From: Mark Warwick <Mark.Warwick@arun.gov.uk>
Sent: 19 March 2021 17:34
To: Simon Davis <Simon.Davis@arun.gov.uk>
Cc: Daniel Vick <Daniel.Vick@arun.gov.uk>
Subject: 261 Aldwick Road, Aldwick

Planning Application Ref: AW/279/18/RES

Location: 261 Aldwick Road Aldwick PO21 3QU

Purpose of visit: Ad-hoc inspection of approved Tree Protection Measures

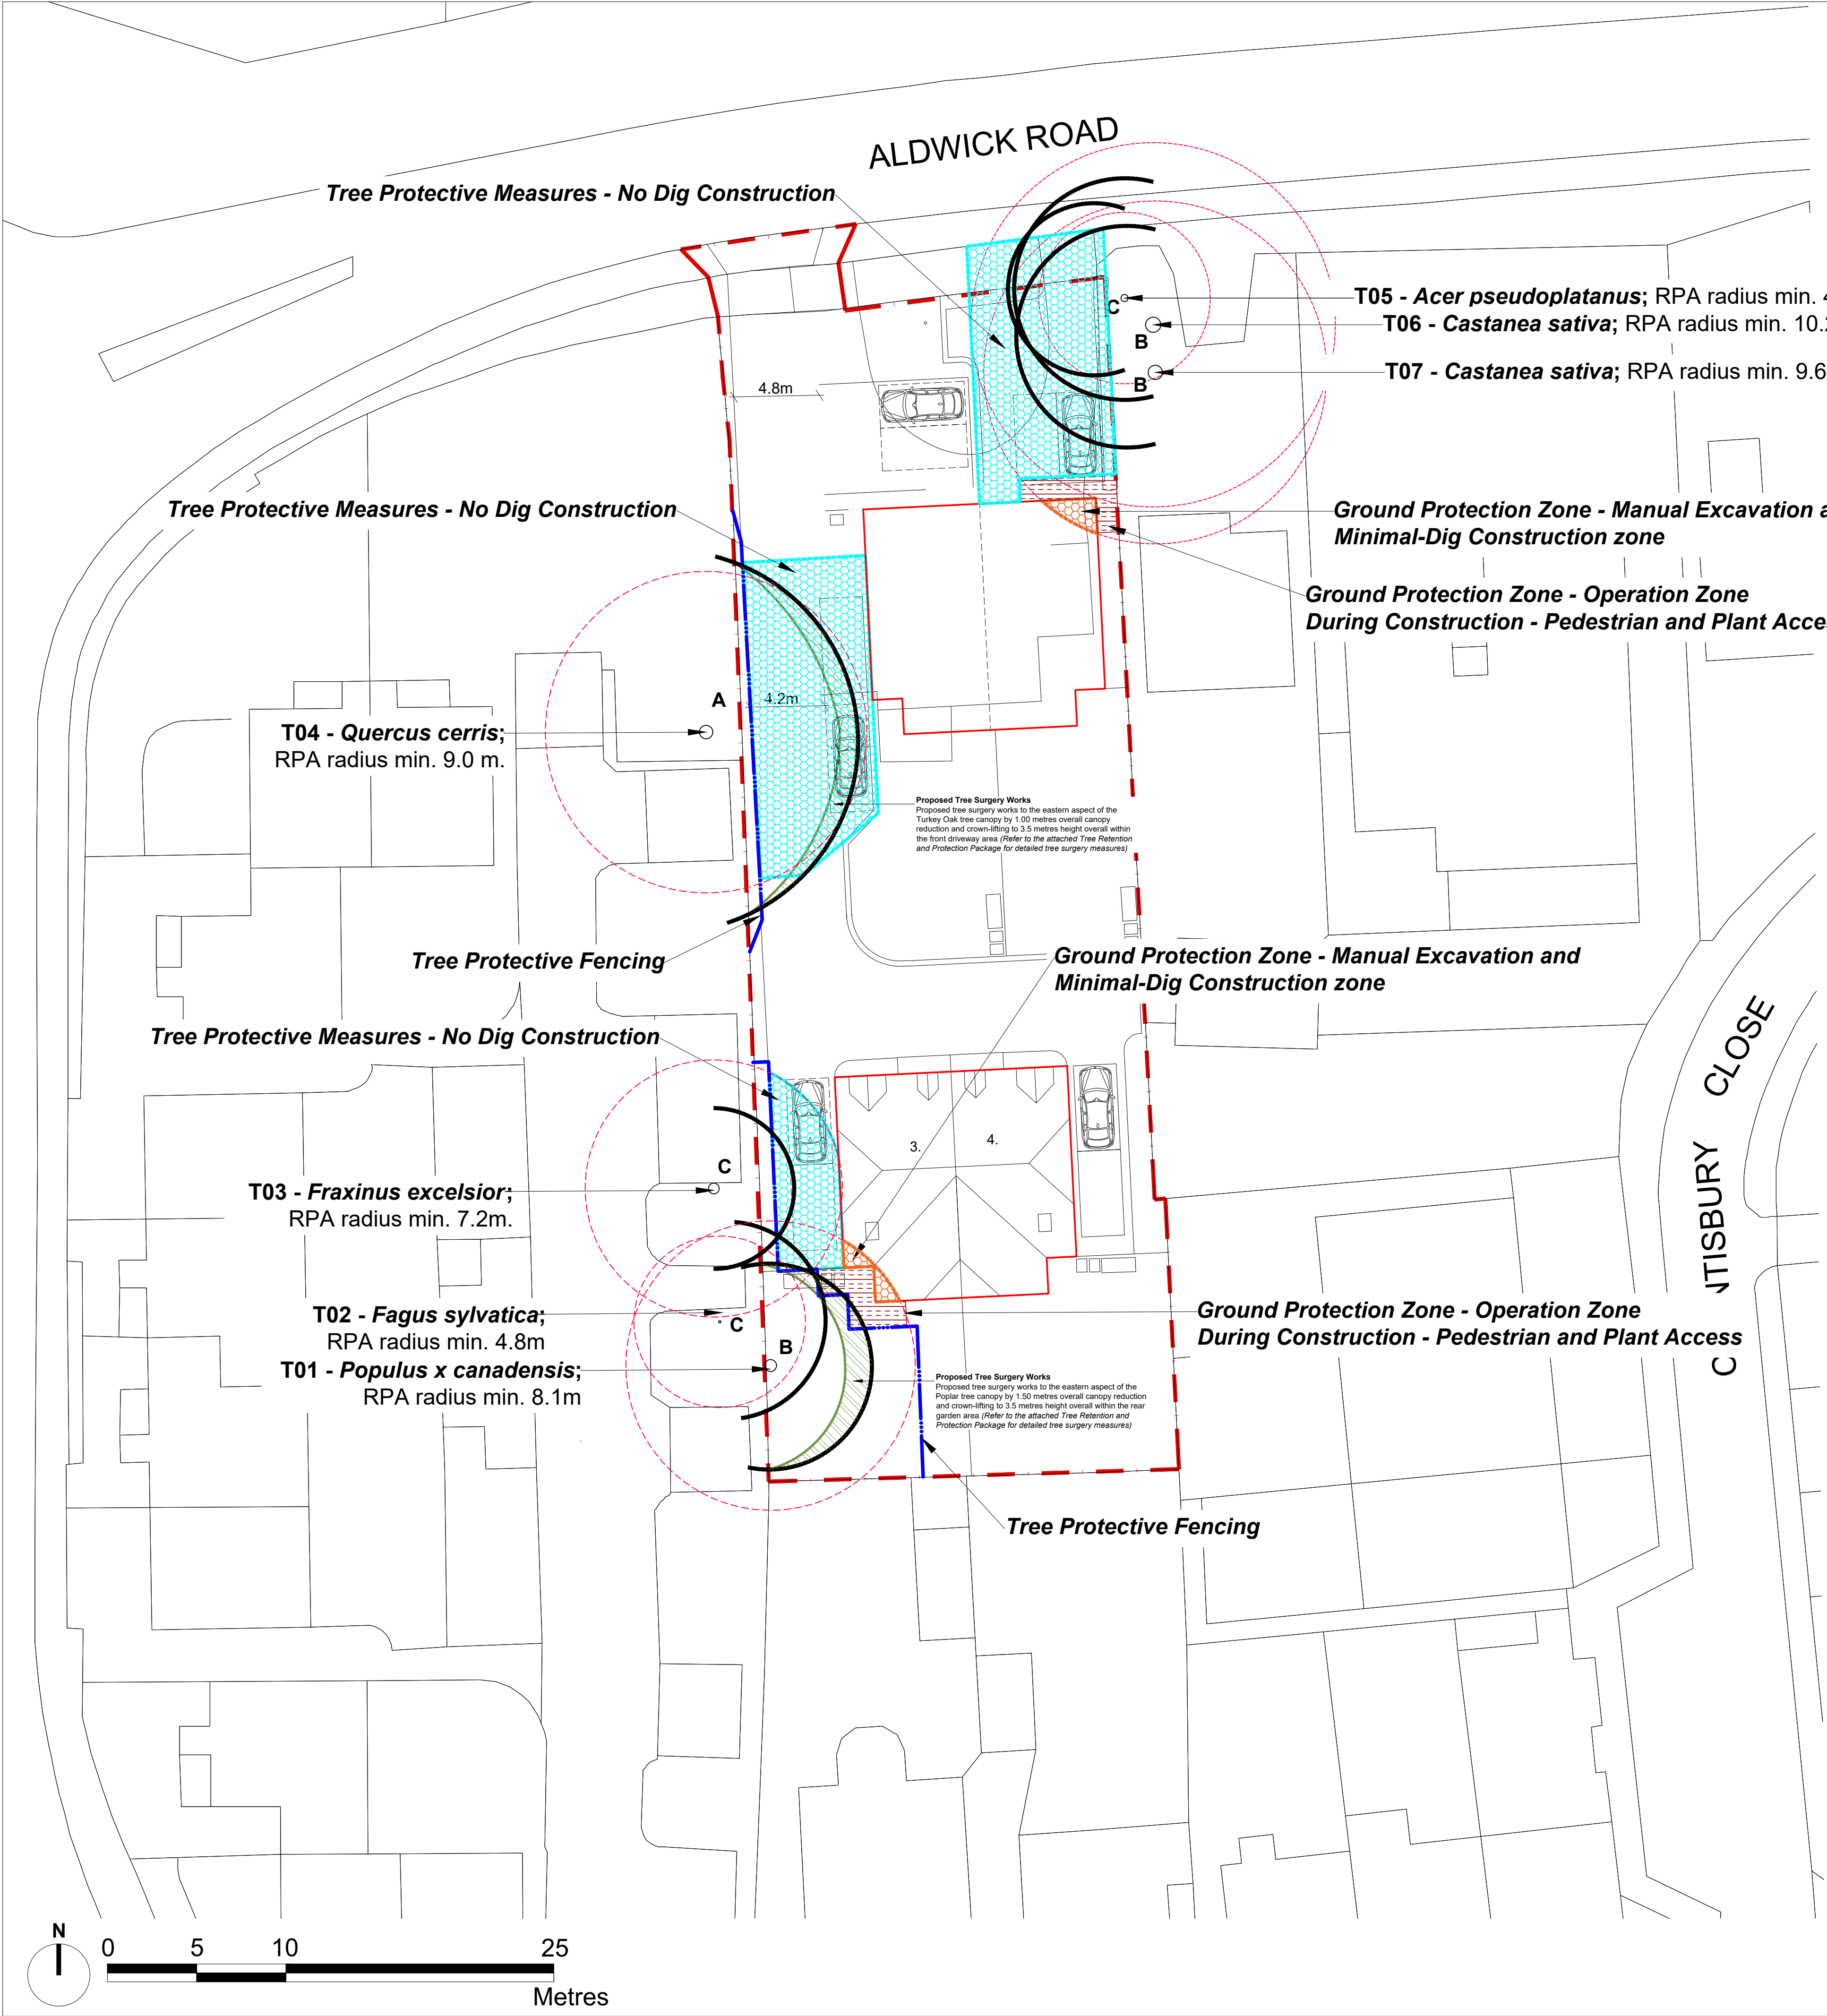
- Materials are also being stored within the now unprotected RPA of T04.
- Despite large areas of RPA being identified for 'No-dig' construction, there was no preparatory ground protection in place. This 'No-dig' area has therefore been compromised once more and we need to ensure adequate ground amelioration and protection is undertaken promptly.

- It is likely that significant damage to the most valuable tree affected by the development has occurred once more, in the form of substantial ground compaction - as a direct result of the activity by groundwork contractors employed by the developer.
- Urgent action must be taken by the developer and their project arboriculturist to arrange for the careful removal of all materials stored within the RPA of T04, effective ground amelioration and installation of ground protection as per the approved plan – as mitigation and to prevent further damage.

- This incident should be investigated to determine how this event occurred and referred to our enforcement team to consider any further action. Given the gravity of these omissions, the probable extent of damage sustained and risk of ongoing damage occurring; my personal recommendation is that you place a **Temporary Stop Notice** across the site until such time as we are confident that appropriate investigation, ground amelioration, installation of approved protection measures has occurred under the direction and supervision of their project arboriculturist.
